**From:** Kathy Craggs [REDACTED]  
**Sent:** 13 October 2020 11:54  
**To:** Finlay Gardner <Finlay.Gardner@arun.gov.uk>  
**Subject:** Ref AW/246/20/HH

It has come to our notice of a proposed planning application by our neighbour Mr J Evans of 14 Regis Avenue, Aldwick to extend his existing garage and make building changes for a new porch to the front of his house.

PROPOSED PORCH AND GARAGE EXTENSIONS AT 14, REGIS AVE., ALDWICK
FOR MR. J. EVANS.

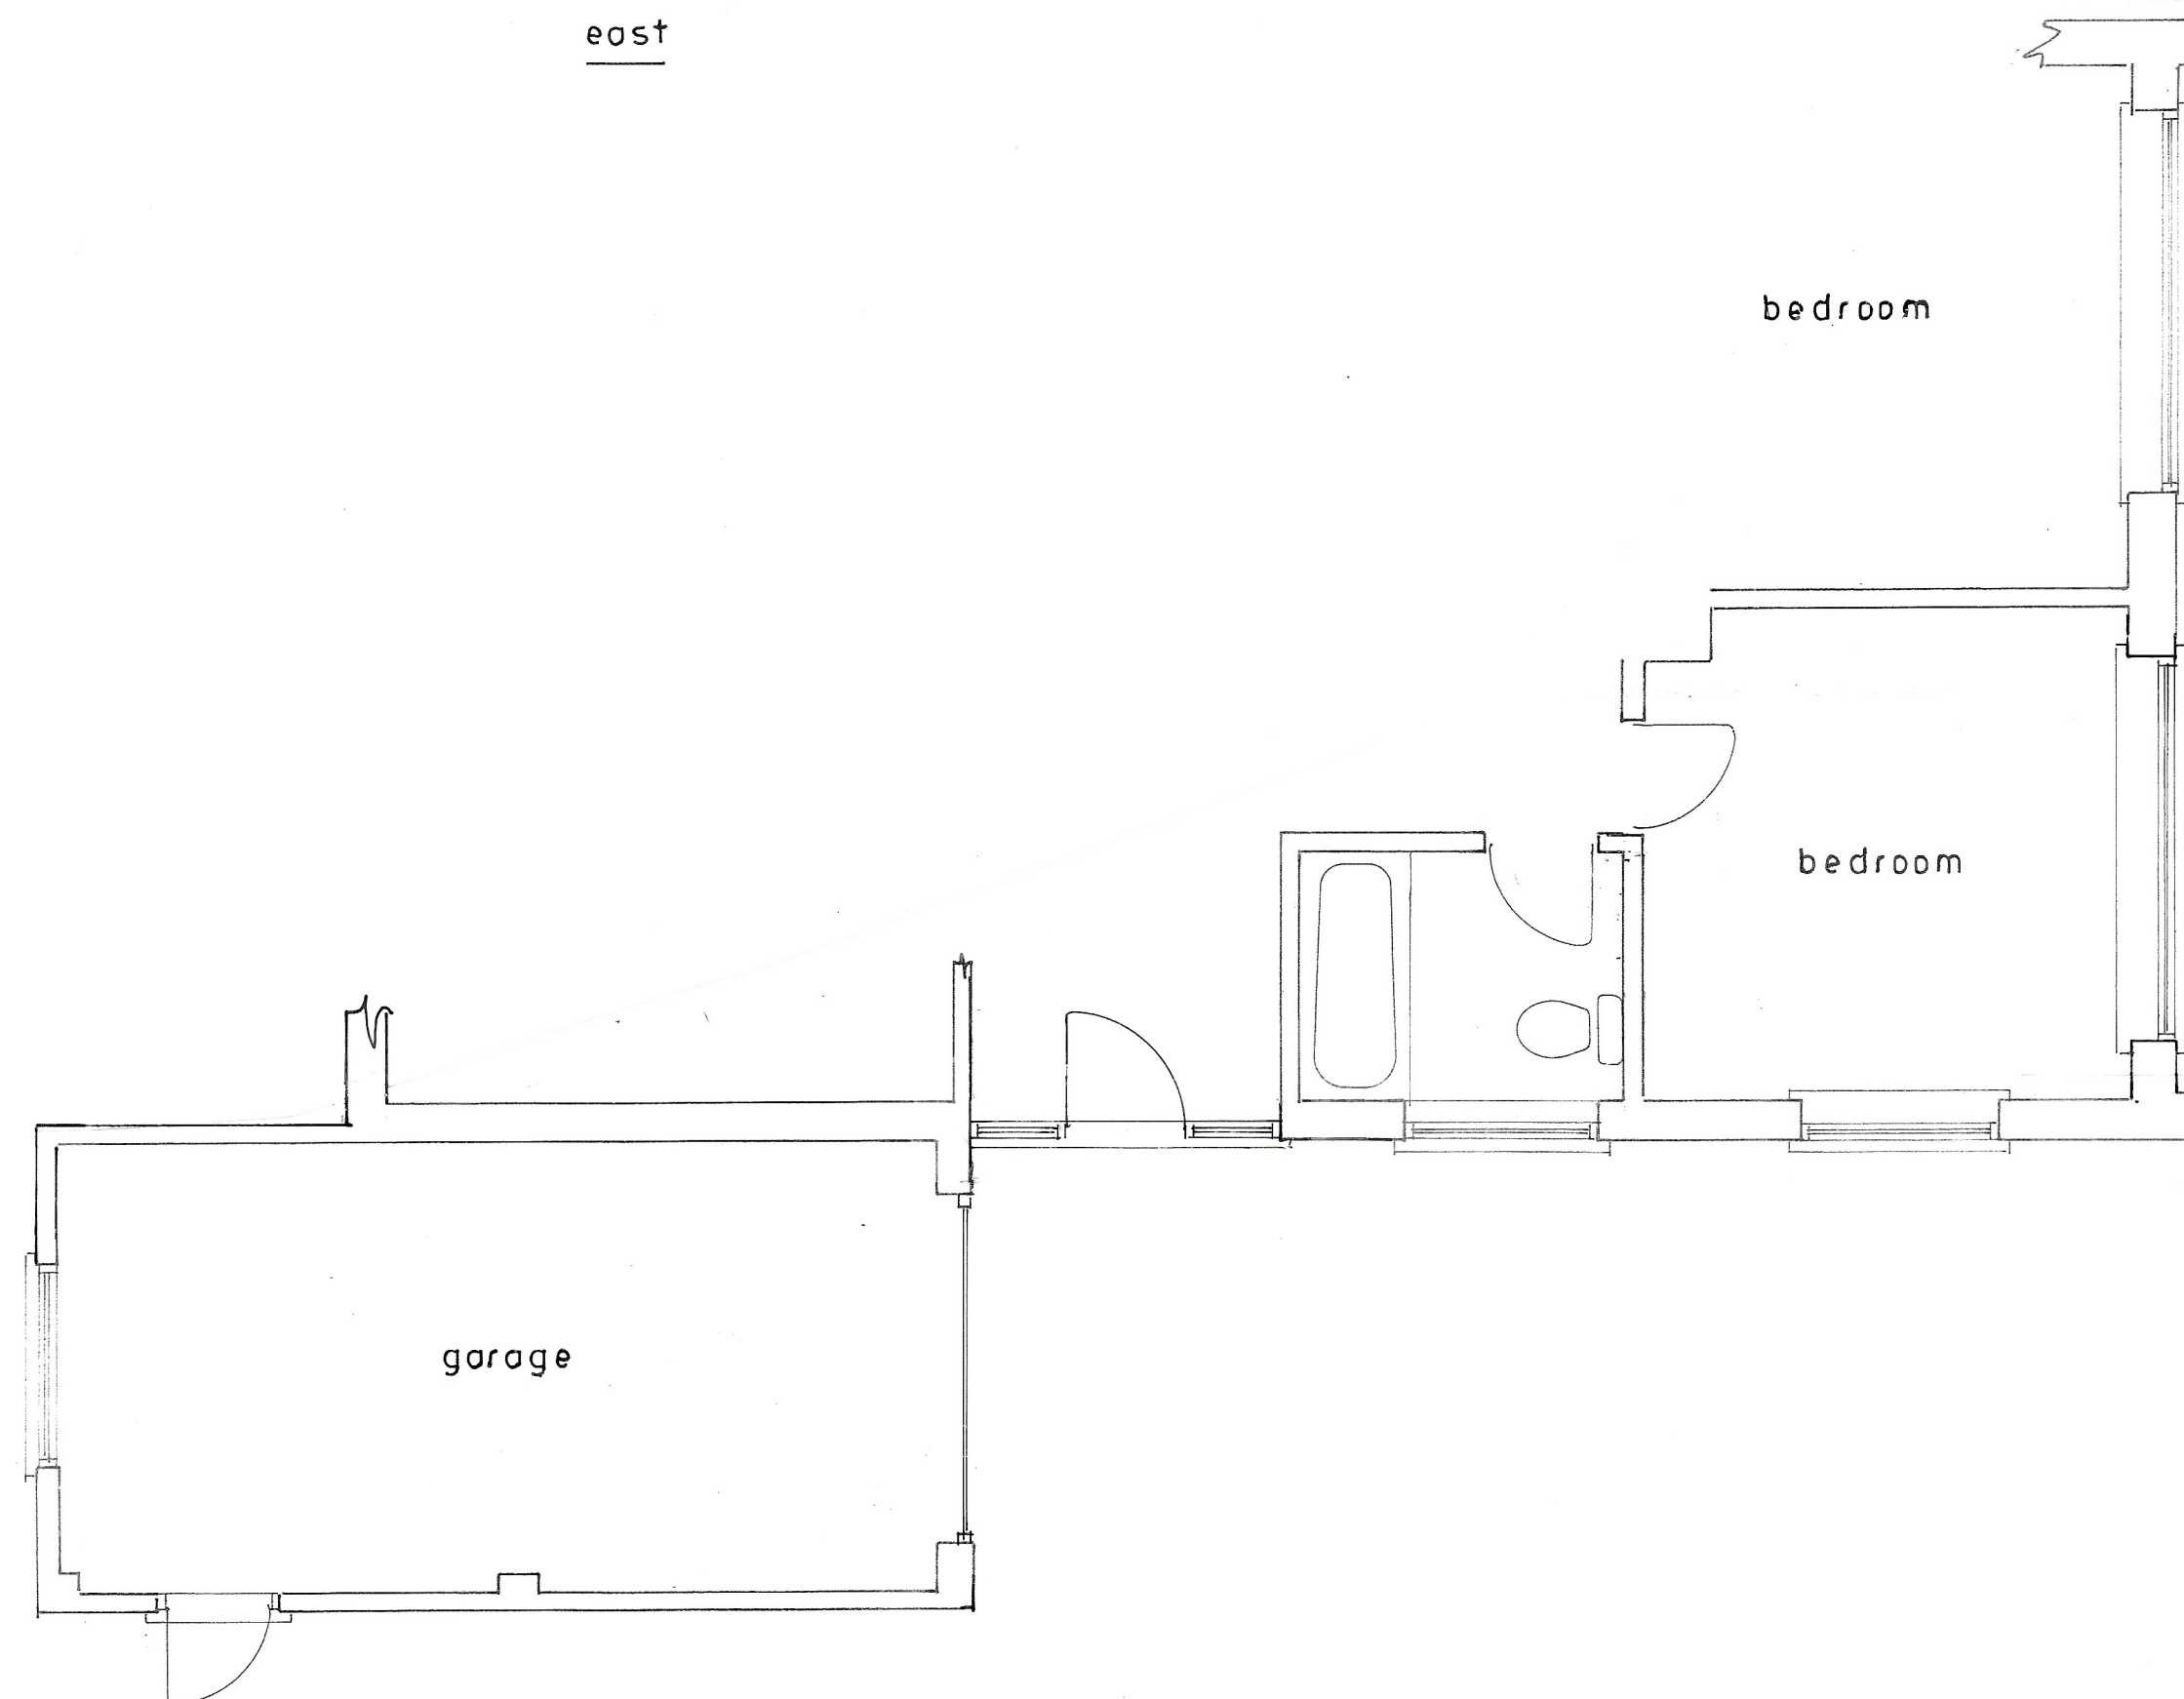
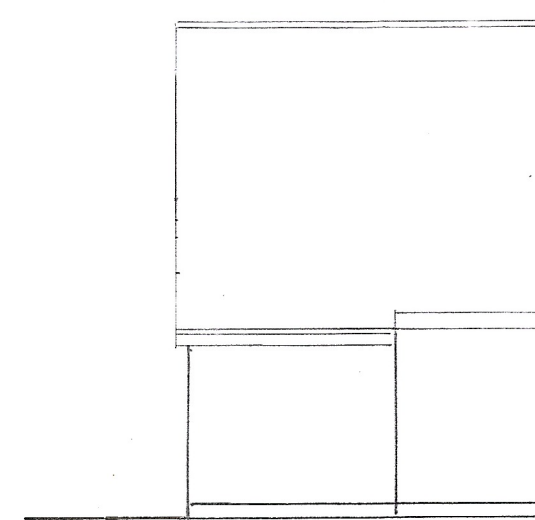
We have no objection to the new porch going in, however we would like to know the councils view and where we stand with right to light as we currently enjoy the evening sun through our lounge side window which measures 1800mm x 600mm.

After looking at the plans for the proposed garage extension the wall of which would project opposite our window and block out our light because the height of the wall would be above our eaves level as we live in a chalet style house. This would negate any benefit from having the window which was there when the house was built in the 60,s.

Secondly, we are concerned about the close proximity of the proposed foundations to our waste water and sewer pipes especially the vibration set up during excavation and the distinct possibility of cracking from this work. These pipes are glazed earthenware which are brittle by there very nature and are nearly 60 years old.

We are also worried about a smaller waste pipe from our kitchen which runs below and across our lounge to connect with the sewer pipe via a gully. We are in for big trouble if this pipe becomes dislodged as a result of the proposed works.
